Our ref: DOC20/457448

Senders ref: SSD 10416

**Subject: Notice of Exhibition – Powerhouse Parramatta**

EES has reviewed the SSDA Report – Flood Risk and Stormwater Management prepared by ARUP, dated April 2020 (the report) and makes the following comments which are generally confined to the methodology used for the assessment as outlined in the report.

Job No 273467	Figure Status Final
Figure No P1.10-0.10A-MOF	Issue 1

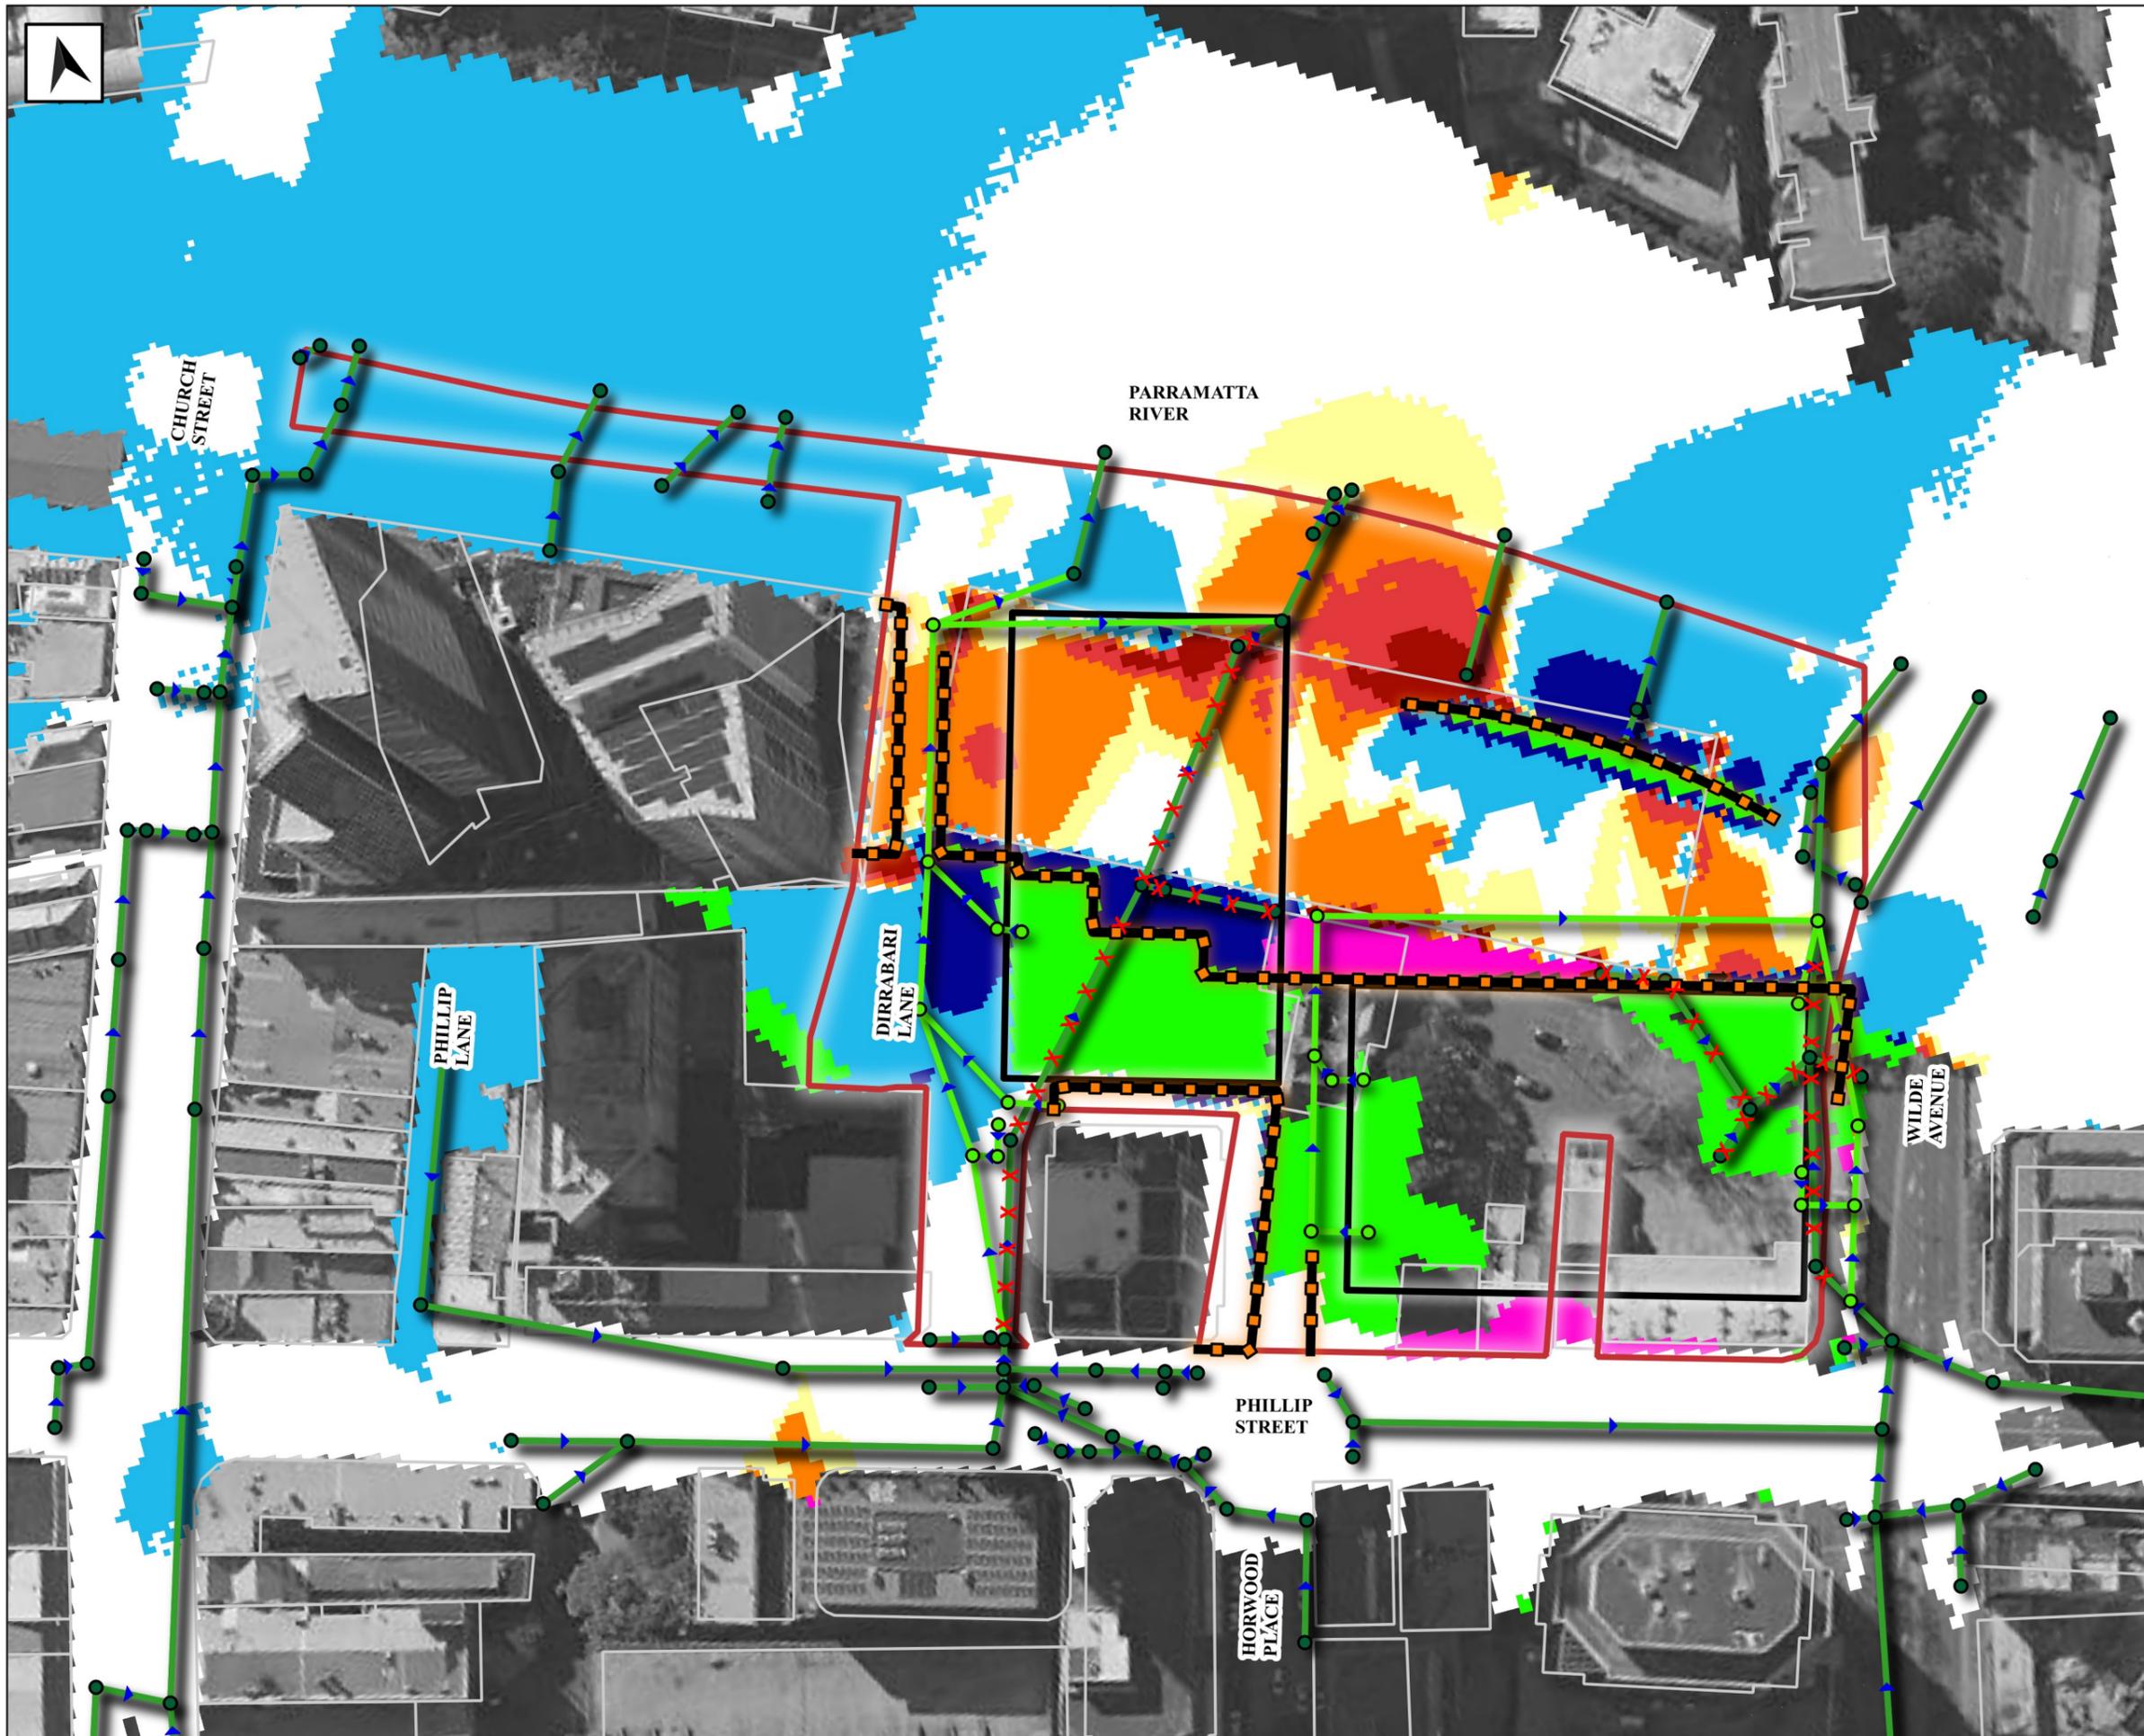
- It is also not clear, whether the proponent adopted a no flow ingress approach above the FFL as indicated by map P1.0-PMFD. Though, there is inconsistency between the map and the report's discussion. The map shows the buildings site surrounded by water while the buildings are flood free, while the report indicates that post-development condition for the PMF is shown to be flooded by more than 2m of floodwaters. This needs to be clarified.

- Map P1.0-PMFH shows the buildings in PMF are largely within the H6 hazard categories. Therefore, due to the significance of this infrastructure, it may be prudent to address structural measures required to ensure the structure of the buildings can withstand floodwater forces including debris and buoyancy up to this level.
